**RE: Arboricultural Assessment of Supporting Removal of Tree 130 Sydney Red Gum:  
MP10\_0016 - "The Terraces" 2 Cooper Street, Paddington**

**Ref: 246MonTree130[AR-RE-P-1008]**

DRAWING NO: **A-P-1116** REV: **2**
PLOT TEO: 2065/2016

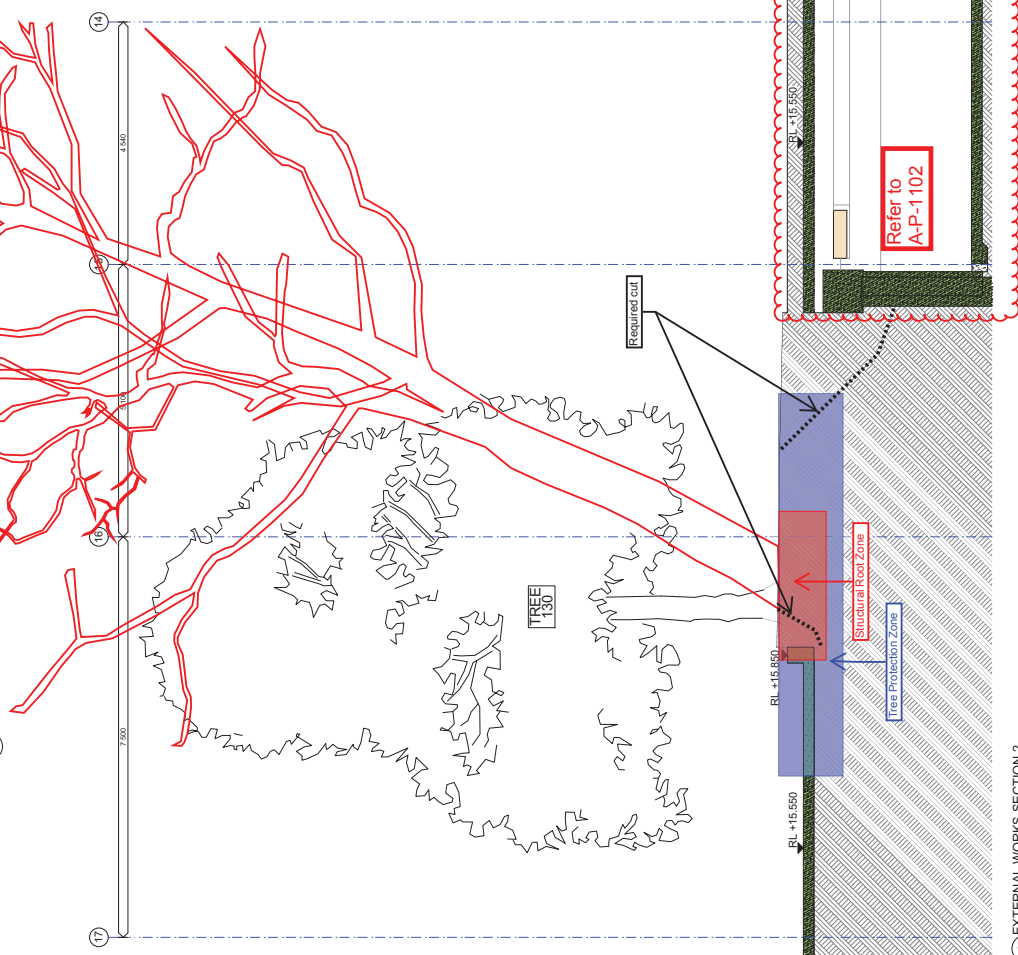
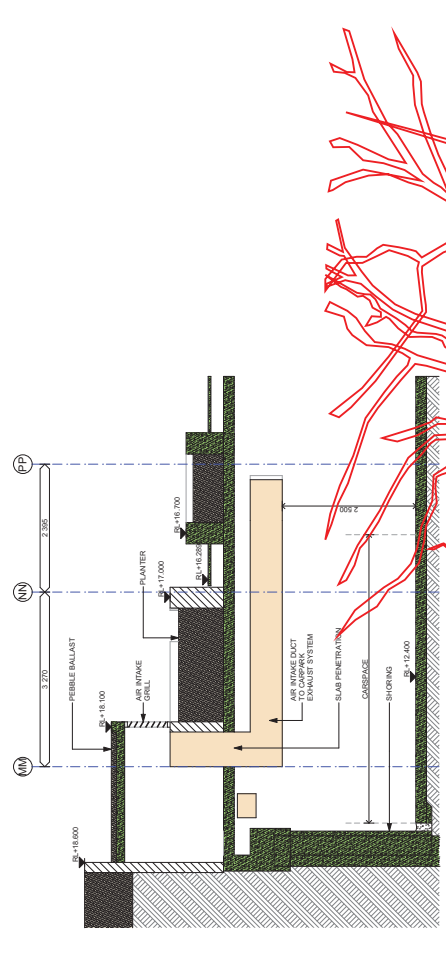
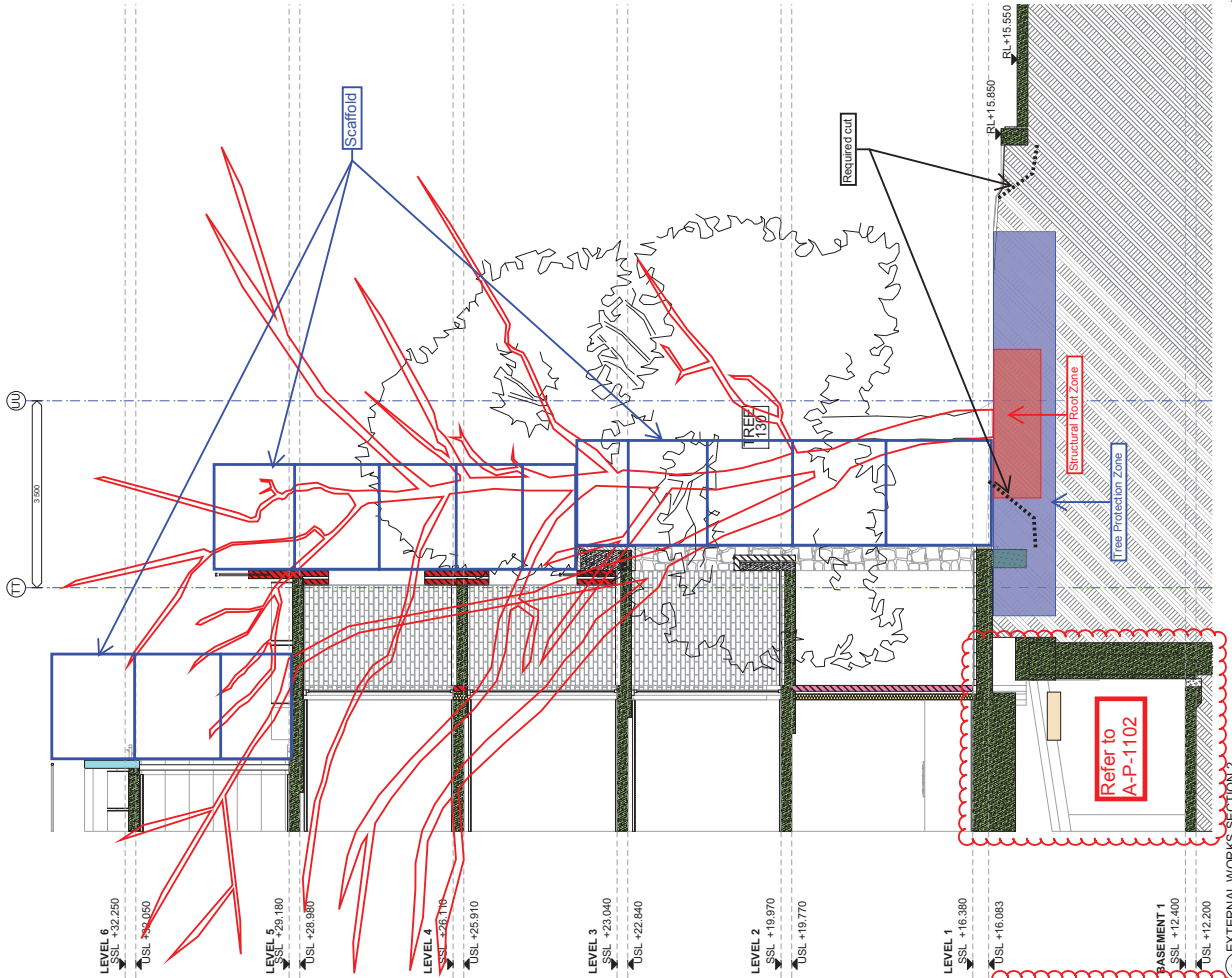
The External Works Sections Drawing A-P-1116, Rev 2 by JPRA has been marked up by Brookfield Multiplex Site Manager 3.12.06 (Attachment C) to accurately show the proposed excavation and the actual lean of the tree.

Section 1 shows the existing ground lines and proposed cut required for the Driveway ramp. Substantial cut for the proposed Driveway ramp is required at the base of the trunk to the west well inside the SRZ. Section 2 shows the cut required for the Basement (Grid line 15) within the Tree Protection Zone (TPZ) (7.2m) and excavation for the Basement (Grid line TT) within the SRZ. The tree will be destabilised by these combined excavation works within the SRZ, particularly given the lean of the tree away from Driveway ramp line of cut.

The crown of the tree is skewed to the south as indicated in Photo C, in the Survey excerpt above and as indicated in the External Works Sections markup (Attachment C). Substantial crown pruning would be required to allow for the proposed building facade and the scaffold required for the construction. As indicated in Section 2 (looking west) scaffolding is required in line with the base of the trunk. Even if the building were to be constructed without external scaffolding, the southern-most leader would need to be pruned to the main junction at approximately 3m above ground level and all the southern branches would need to be pruned to provide reasonable building clearance. This extent of crown pruning would render the tree significantly disfigured such that its ULE would be reduced and the landscape amenity provided by the tree would be lost.
